2024/0420

1 Carr Head Road, Howbrook, Sheffield, S35 7HG

Erection of new boundary fencing and gates (Retrospective).

PROPOSED SITE PLAN 1:500

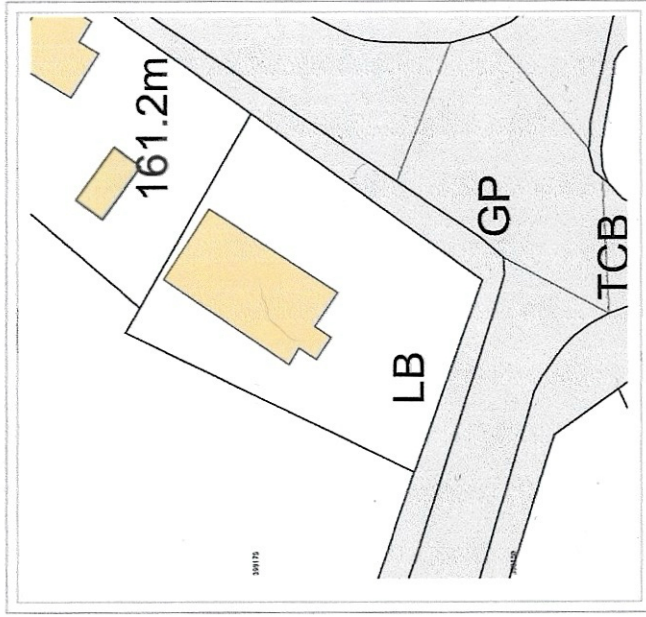
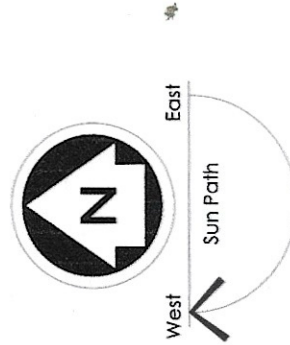
The primary concern in relation to the boundary fence is its impact upon highway safety, particularly in relation to poor visibility at the crossroad junction when entering Hollinberry Lane and Howbrook Lane from Carr Head Road.

Highways DC were consulted on the application and stated that visibility from Carr Head Road to the right (west) along Howbrook Lane is restricted by the horizontal alignment of the boundary wall and fence with just approximately 2.4 metres by 18 metres being achievable without encroaching across the south-west corner and garden of the application plot. Moreover, if the boundary fence were not in place and the vegetation/shrubbery along the site boundary were allowed to grow in height, visibility would be impeded to the same degree, or worse. Therefore, Highways DC raised no objection. Moreover, whilst the concerns raised in relation to boundary vegetation growth are acknowledged, this is not a material planning consideration as the planting of vegetation/ shrubbery does not require planning permission. Therefore, the potential future growth of the boundary vegetation and any associated visibility impacts at the crossroad junction cannot be controlled by the Council.

In considering the above, on balance, it is considered that highway safety would be maintained to a reasonable degree and the proposal is therefore considered to comply with *Local Plan Policy T4: New Development and Transport Safety* and would be acceptable regarding highway safety.
